ASSESSMENT REPORT

Printing Warehouse and Distribution Facility Erskine Park Penrith
MP 08 0016 MOD 3

This report is an assessment of a request to modify the Project Approval (MP 08_0016) for a printing, warehouse and distribution facility at Lenore Drive, Erskine Park.

Drawing title:
LOT 2 SITE PLAN

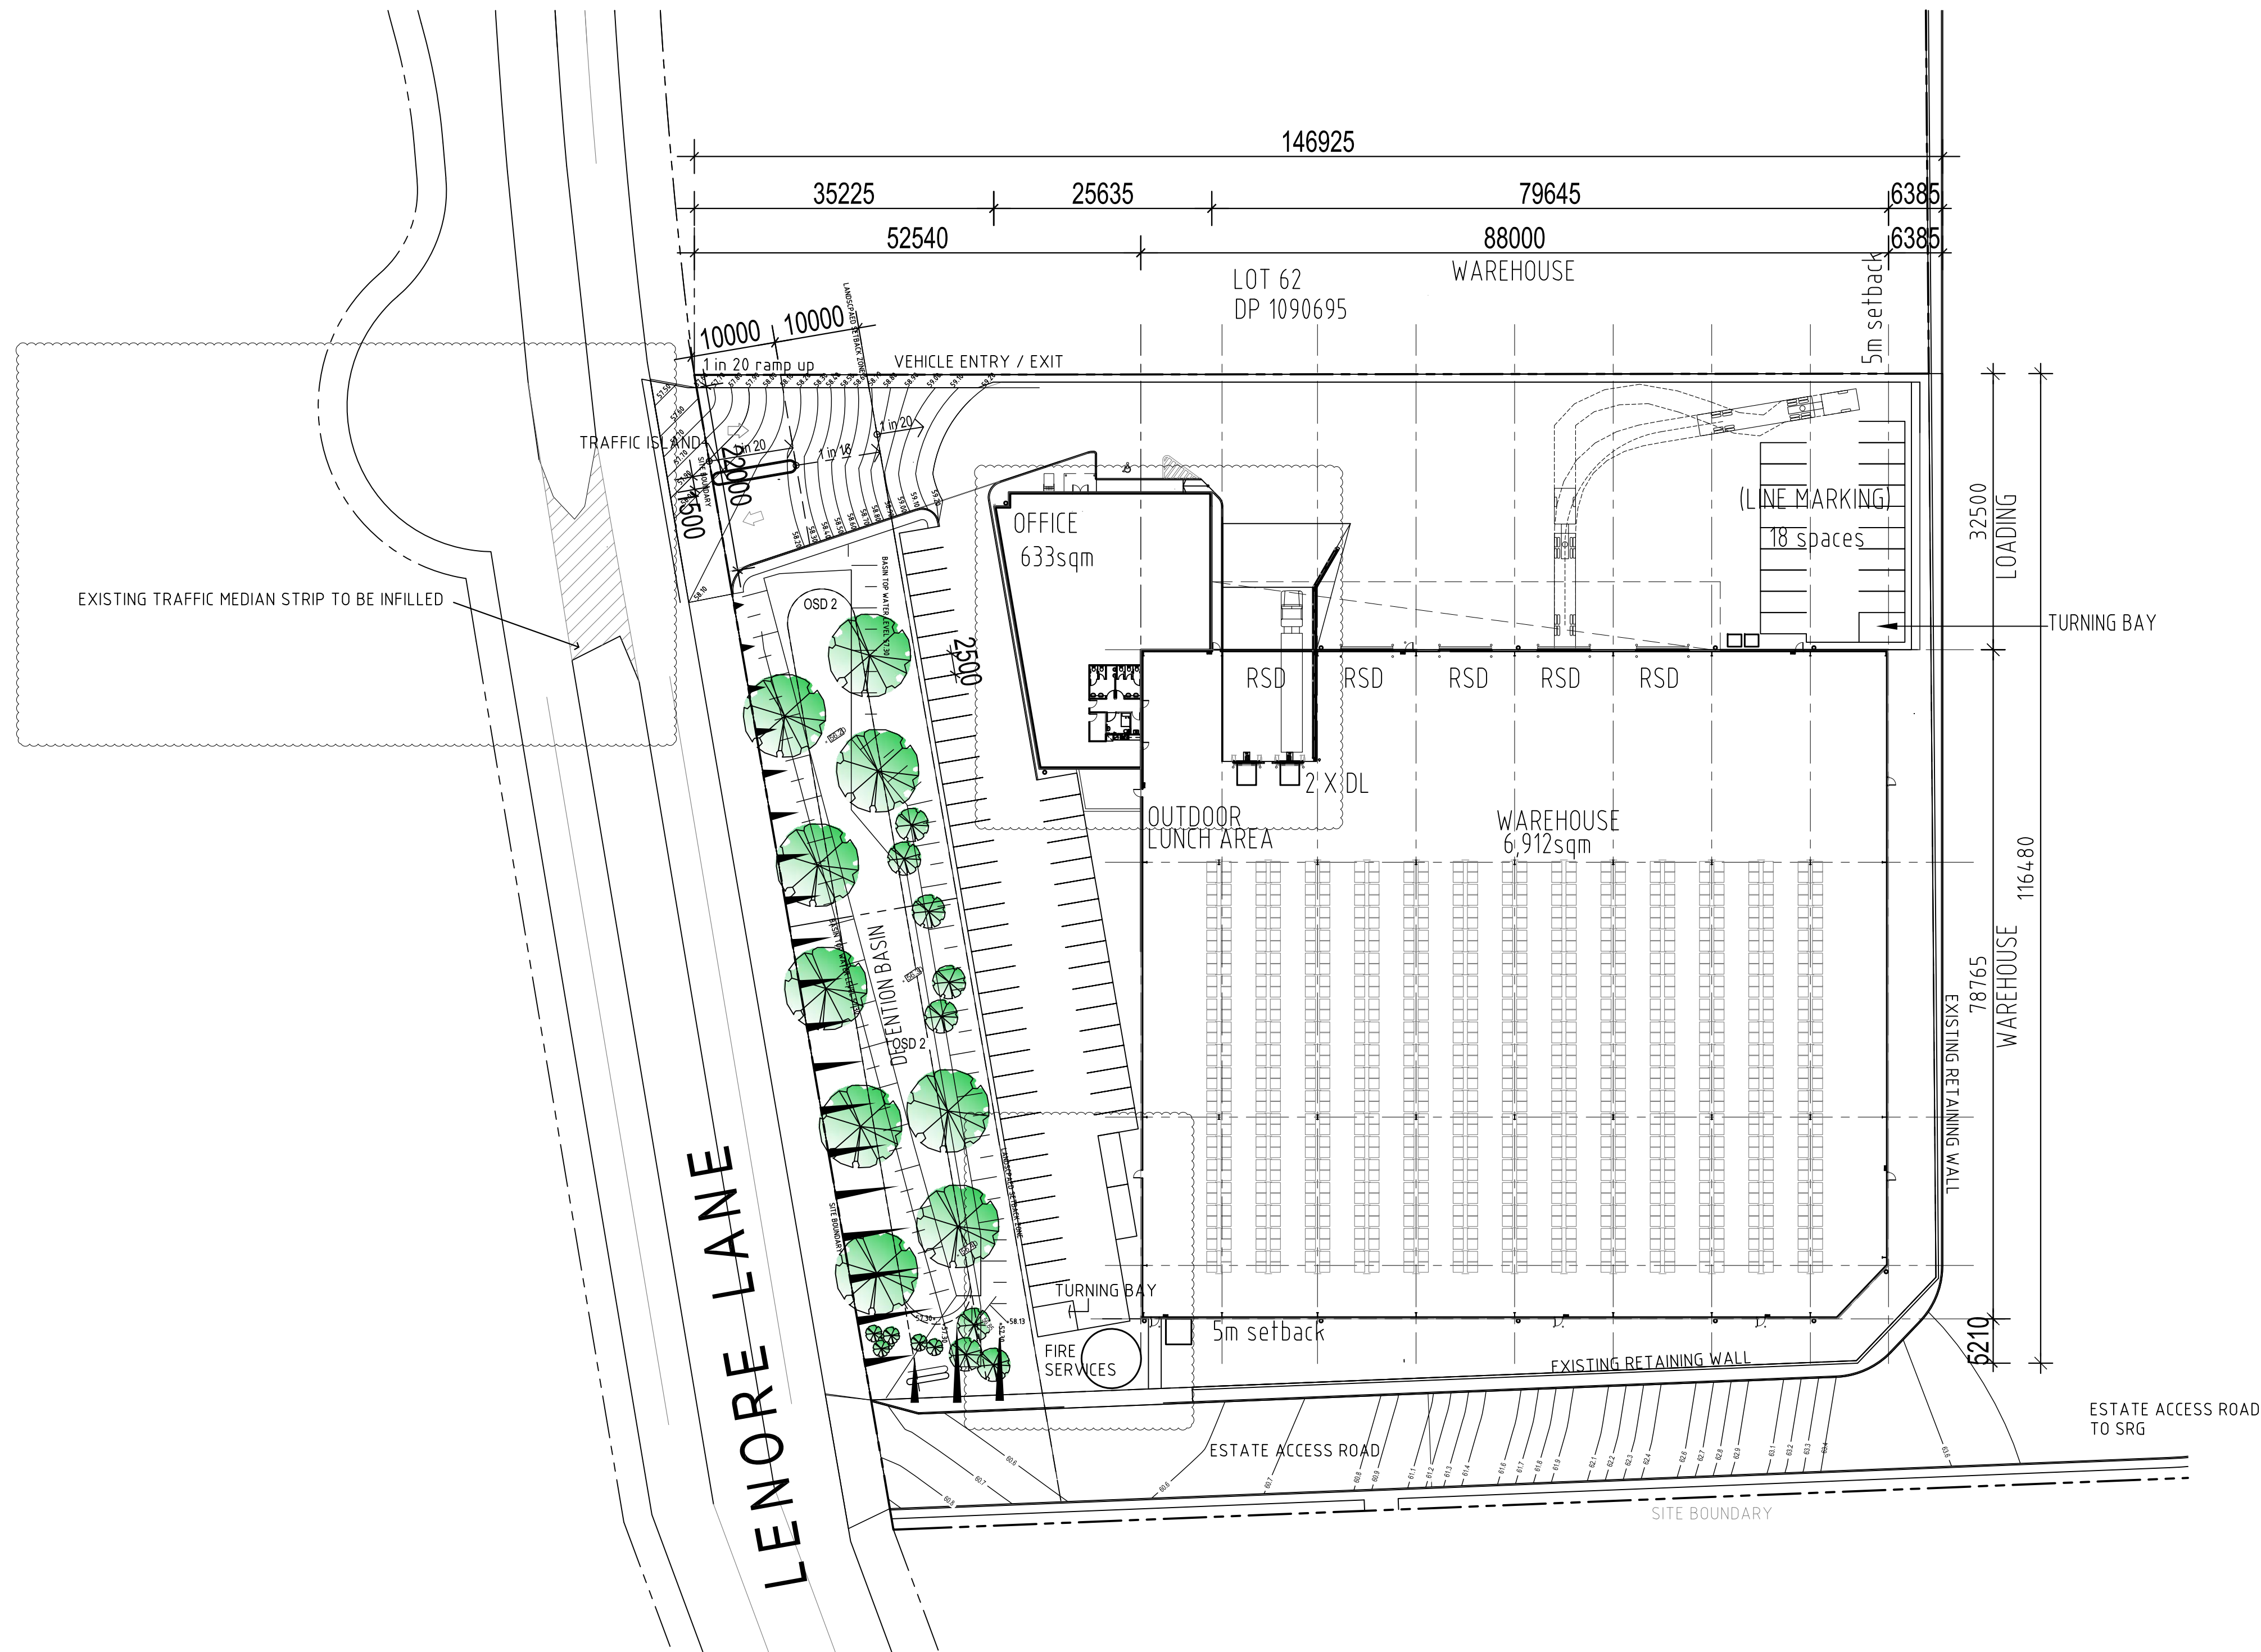
The proposal includes the relocation of the fire services tank from the centre of the warehouse's southern elevation to the estate road (eastern) end.

Council has raised concern that the fire services tank should be relocated away from publicly visible areas, and front fencing should be appropriately designed and located.

The Department considers that the proposed relocation of the fire services tank is acceptable as:

- condition 16 requires that the fire services tank be wholly encompassed by screening;
- the inclusion of landscaping within the warehouse setback areas fronting Lenore Drive and Estate Road will soften the visual impact of the fire services tank; and
- the provision of tank structures is not uncommon within industrial precincts.

This application does not propose to amend the approved landscaping plan. However, the Department agrees with Council's recommendation that the front fencing should be appropriately located and designed to minimise its visual impact. The Department has recommended a new condition accordingly.

Drawing title:
BUILDING ELEVATIONS

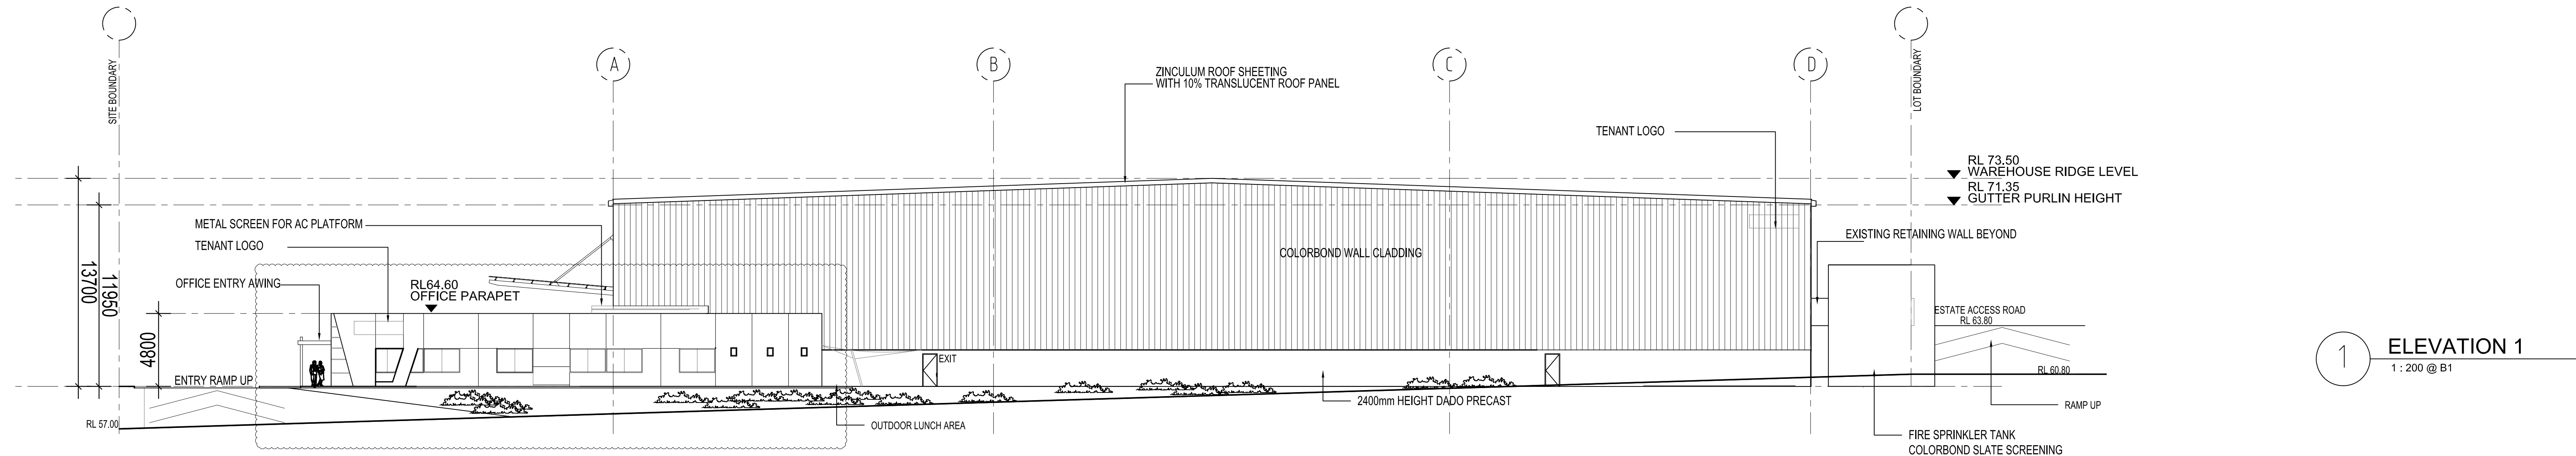
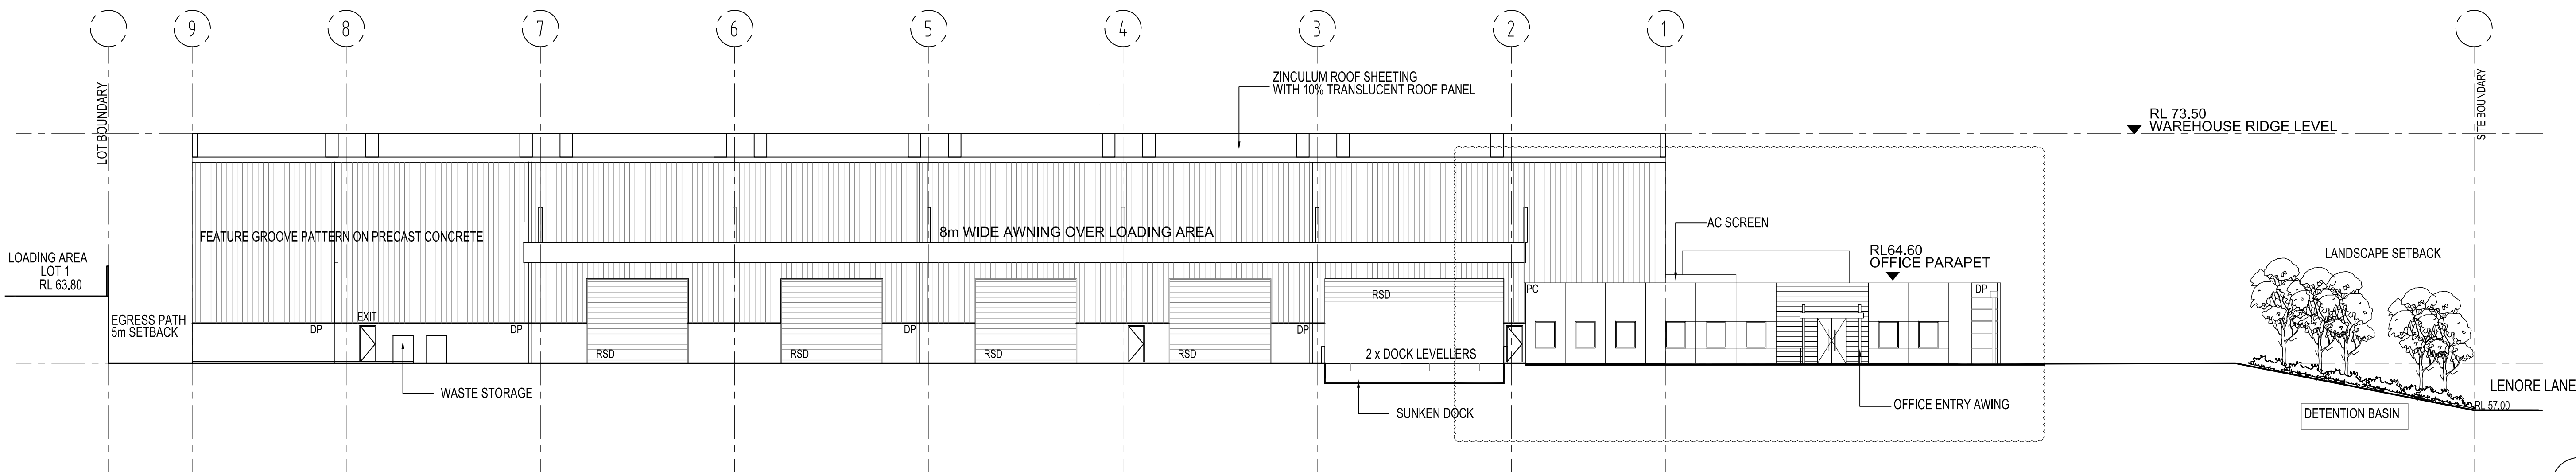
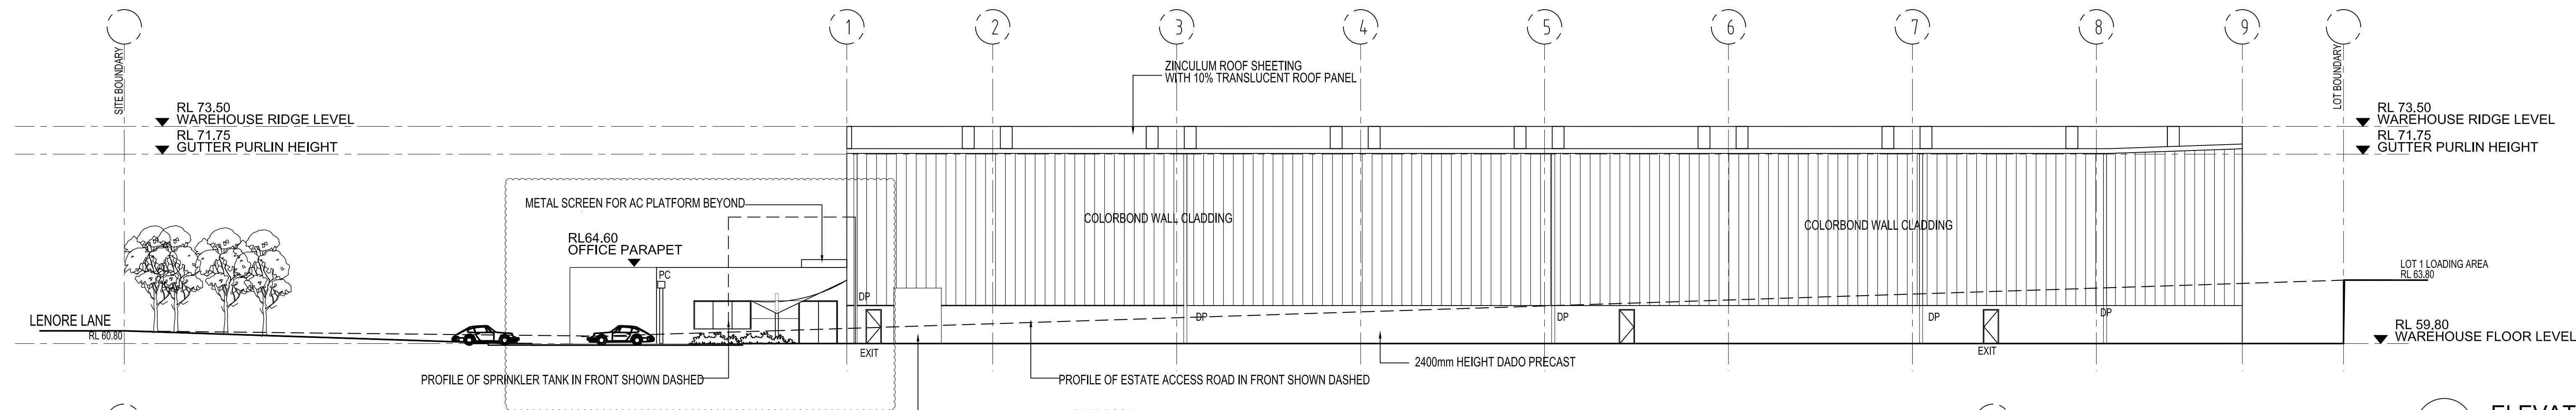
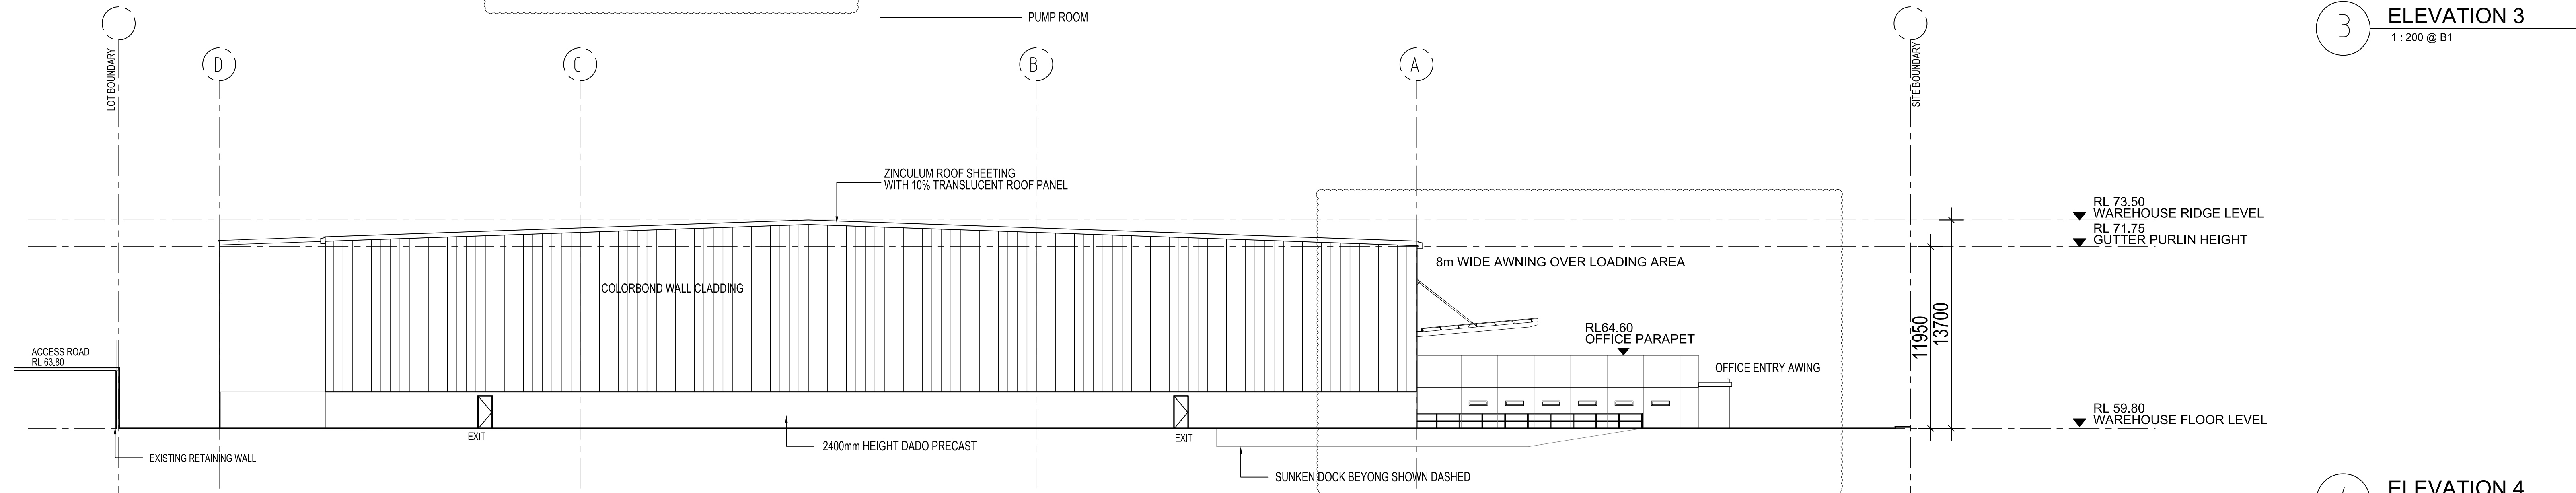
Council considers the presentation of the office a key aspect of the development and is concerned that the proposed modification lessens its architectural merit and that the reduced scale of the office does not minimise the perceived scale of the overall development.

The Department acknowledges that the proposed architectural design of the office building is less engaging than the approved office building. However, the Department considers that on balance the proposed design is acceptable for the following reasons:

Council has recommended that the large southern and eastern walls of the warehouse should be architecturally broken down.

The Department considers that reducing the height of the office building from two to one storey is acceptable as:

- the key Lenore Drive elevation has been articulated through the use of windows and coloured panels;
- the coloured panels pick up on the colour scheme and rectilinear patterning of the warehouse building, which ensures that the office and the warehouse are read as a unified development;
- the use of precast concrete panelling (for the office component) within the Erskine Park precinct is not uncommon and is likely to be robust in terms of weathering and maintenance;
- the approved landscaping includes crowning trees which, when mature, will provide for a appropriate level of screening to the site.

The Department notes that the design and cladding of the warehouse elevations were considered as part of the Department's assessment of the previous modification application (MP08_0016 MOD2). The Department concluded that the design and treatment of the

elevation was appropriate. The current modification application does not include any material alterations to the southern or eastern warehouse elevations and consequently the Department maintains its view that the elevation is acceptable in design terms.
